Recommendation Report for Planning Permission for Works or Extension to a Dwelling

REF NO: P/32/19/HH

LOCATION: 56 Harbour View Road
Pagham
PO21 4RQ

PROPOSAL: Single storey side extension

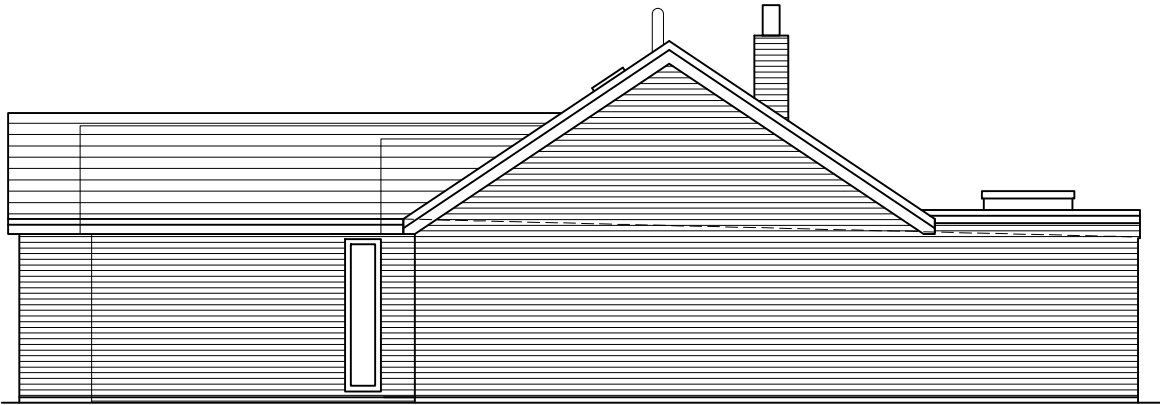
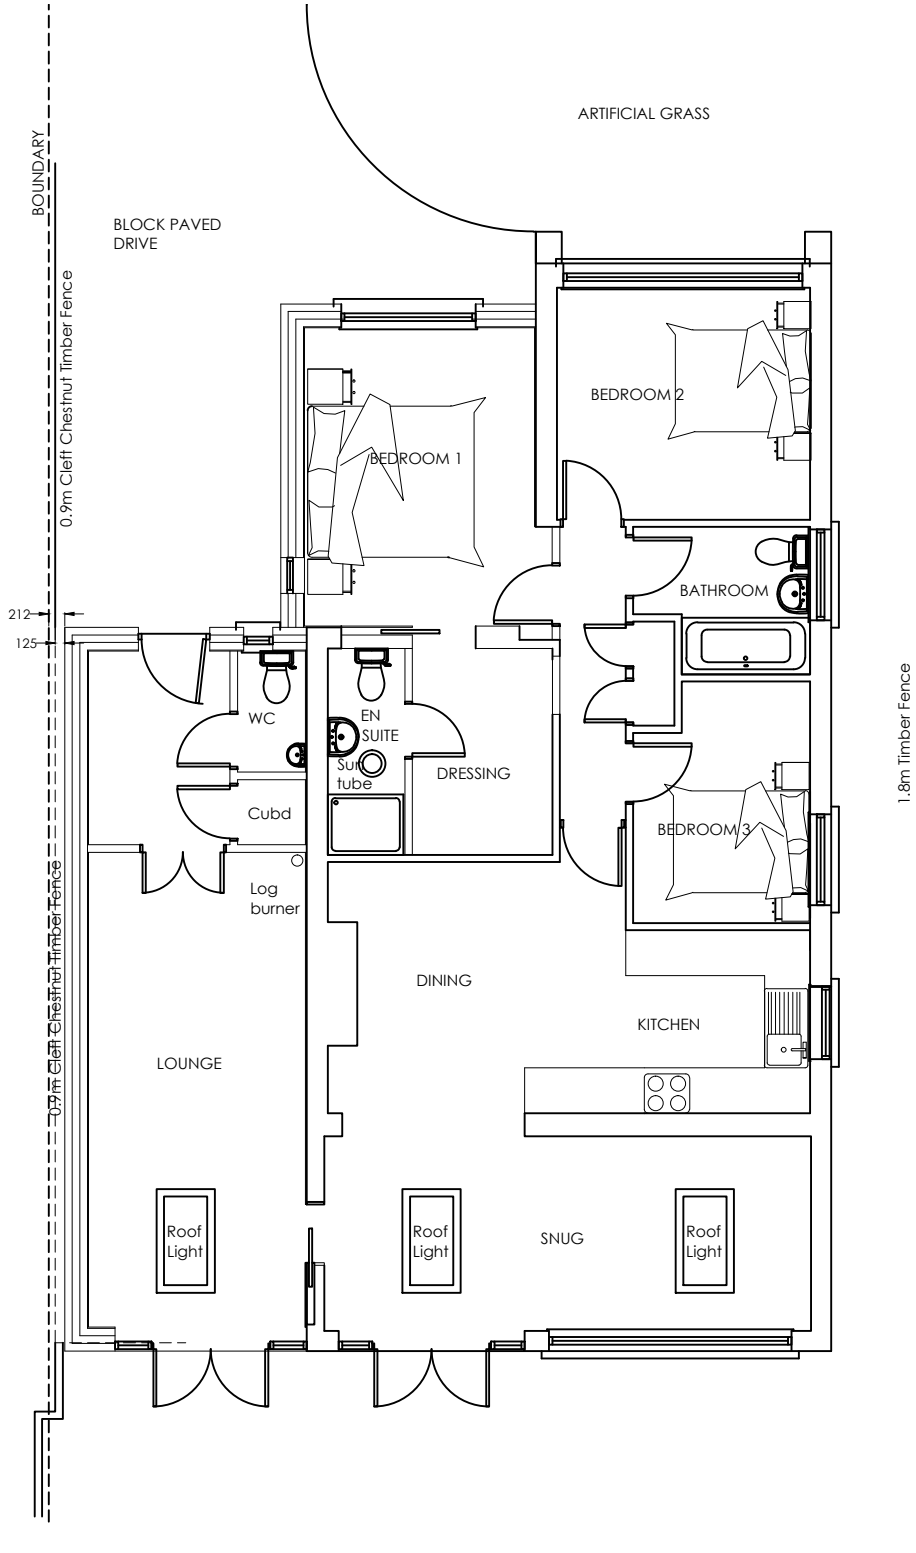
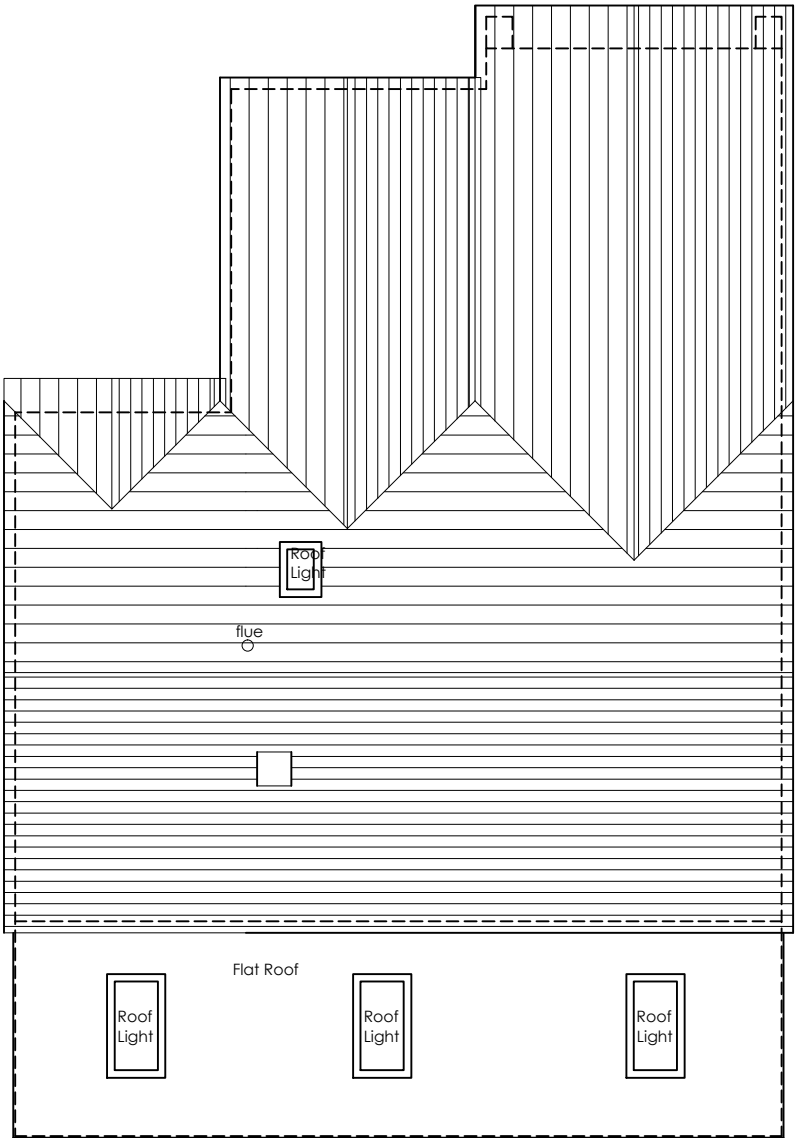
The proposal is located to the front and side of the dwelling and as a result is highly visible from the street scene.

The proposal will run along the side elevation of the dwelling and will also infill part of the front elevation of the dwelling however retains 1m to the principle elevation and 8m to the front boundary of the property. This is considered sufficient distance as to not appear unduly dominant upon the street scene.

The existing flat roof of the garage will be converted to form a pitched roof which will match that of the host dwelling and this therefore adds bulk to the northern elevation. The garage which runs along the side of the dwelling will be converted to form a porch area and lounge. The surrounding properties are similar in style and design however there are some examples nearby which have similar development to the front of the property and therefore it is not considered to appear adversely out of character.

Cladding is also proposed to the front elevation of the extensions however this will match that of the host dwelling and therefore appears well integrated.

The extension to the front of the property will have a depth of approximately 4m and run approximately 3.3m along the front elevation of the dwelling to a height of 3.65m. The front of the garage will also alter to form a porch area and will have a gable to match the existing front additions with a height of 3.4m.

The flat roof of the garage will be converted to a pitched roof to match that of the host dwelling with the roof extending around 3m in width. Due to the siting of the neighbouring property at No.54 and with no side windows this is not considered to give rise to any adverse overlooking or overshadowing upon neighbouring amenity. 3m is also retained between the front extension and boundary to the north and again is not deemed to give rise to any unacceptable impacts upon amenity.

The garage door will be replaced with front door and there will be an additional window which will have

views over the street scene. There will be 1 window to the front extension facing north however due to its siting and size, it is not deemed to give rise to any adverse overlooking.

The proposal due to its siting its not deemed to harm neighbouring amenity by way of overbearing, overshadowing or overlooking and accord with DDM1 and DDM4 of the Arun Local Plan.

BLOCK PLAN

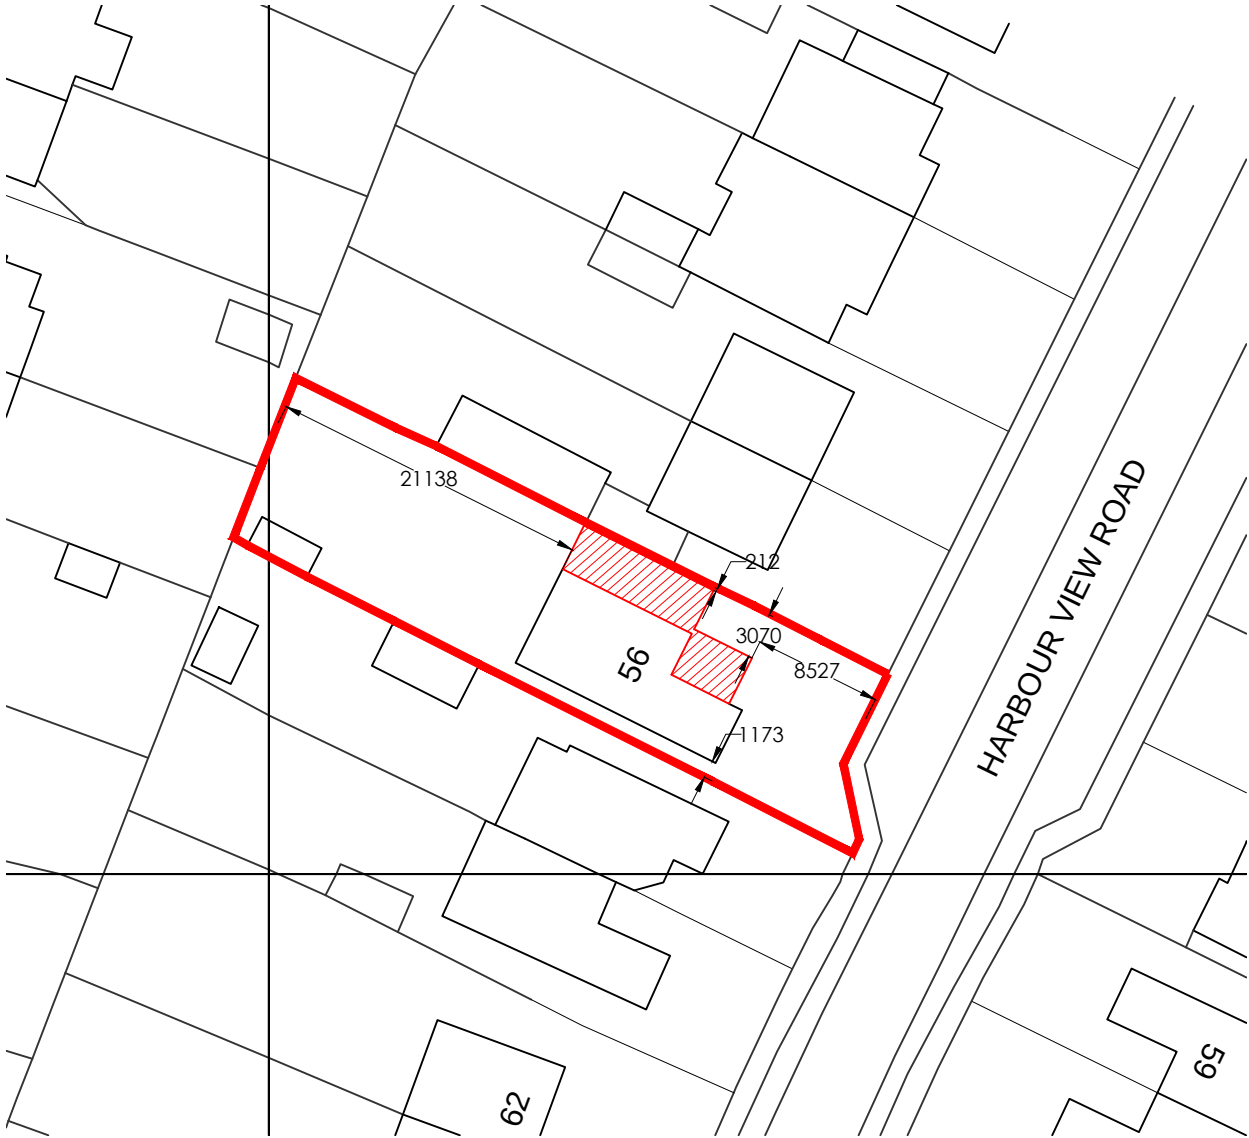
Whilst the conversion of the garage will result in the loss of a parking space there is sufficient space retained to the front of the property for 1-2 cars and the proposal is therefore not deemed to adversely impact upon parking or highway issues.
